# CITY OF ALBUQUERQUE

**Re: Chevron Corner Market, Palomas Avenue / San Pedro Drive NE, Site  
Development Plan**

**Engineer's Stamp dated 4-07-05 (D18-D49)**

CONCEPTUAL GRADING AND DRAINAGE PLAN
CHEVRON GAS STATION 04-01-05
1" = 30'-0"

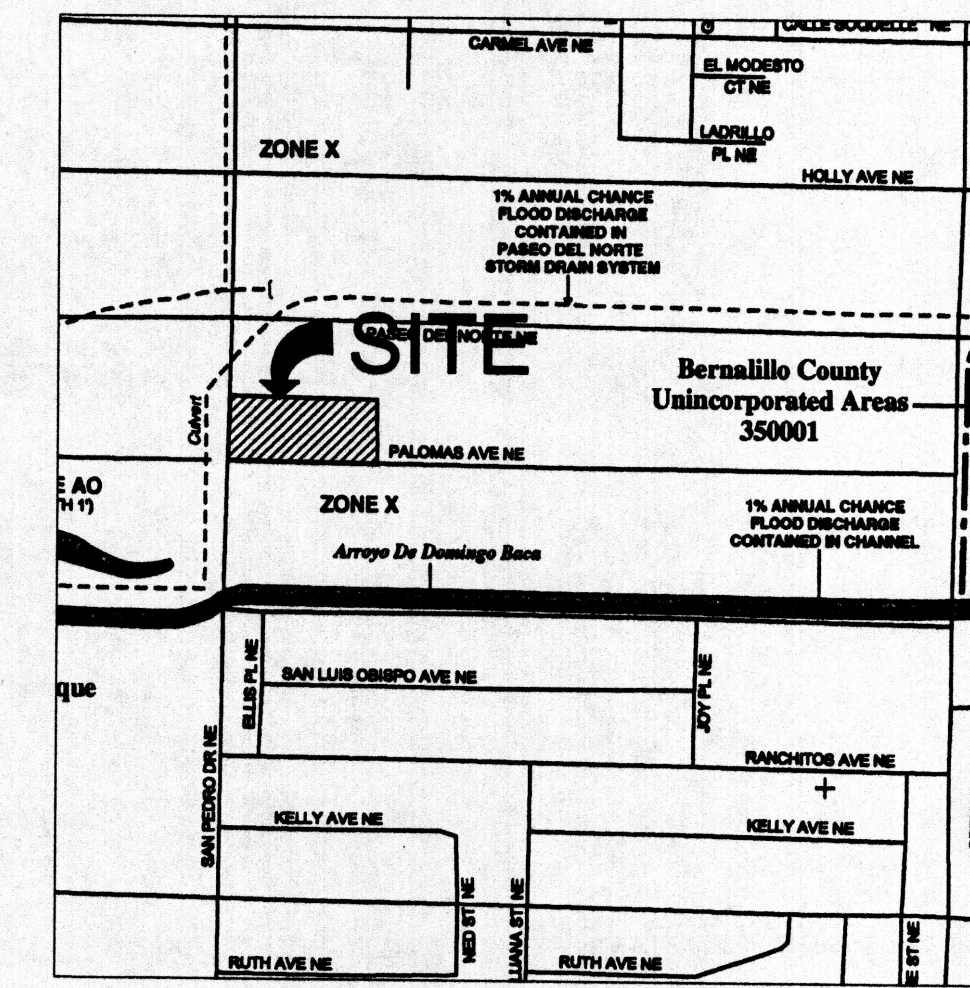
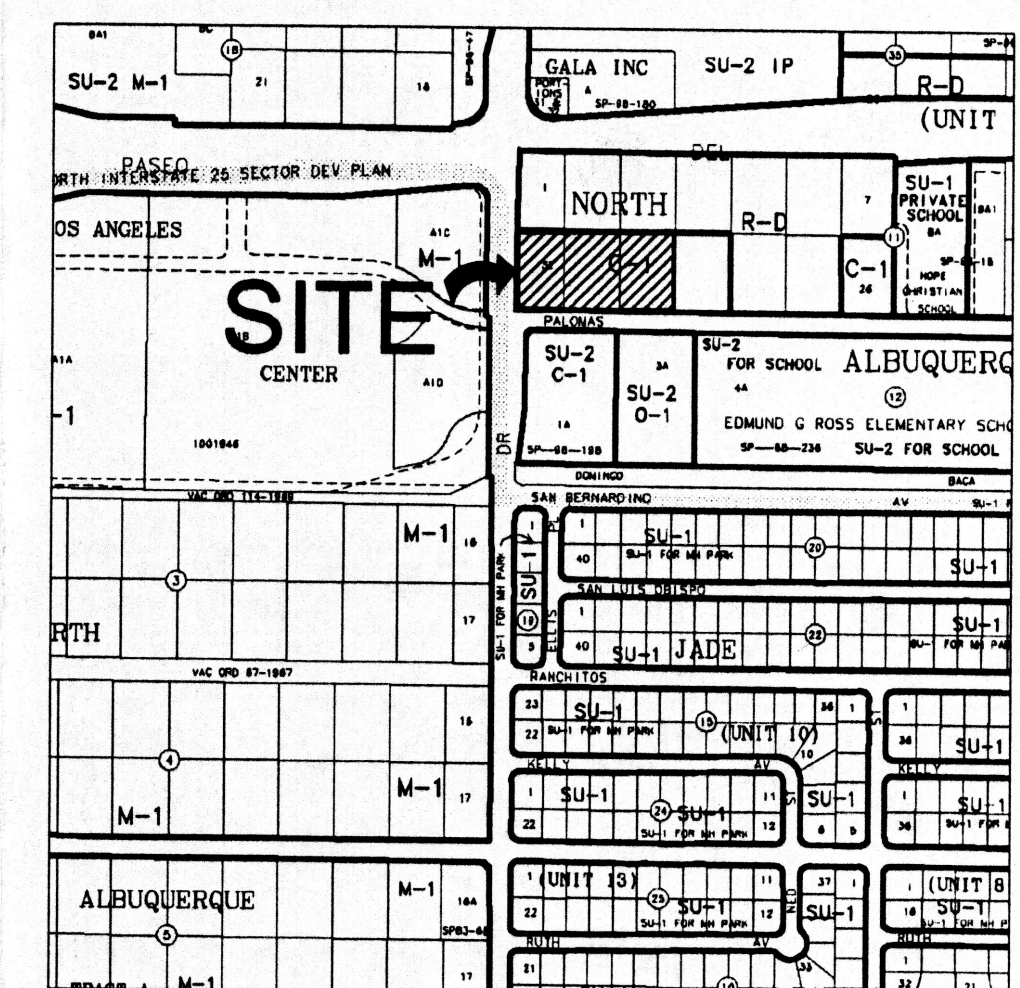
1. Clearly define which items will be built under work order. Will the proposed storm drain referred to in keyed note 9 be built under work order?
2. Provide invert elevations and details for all proposed drainage structures.
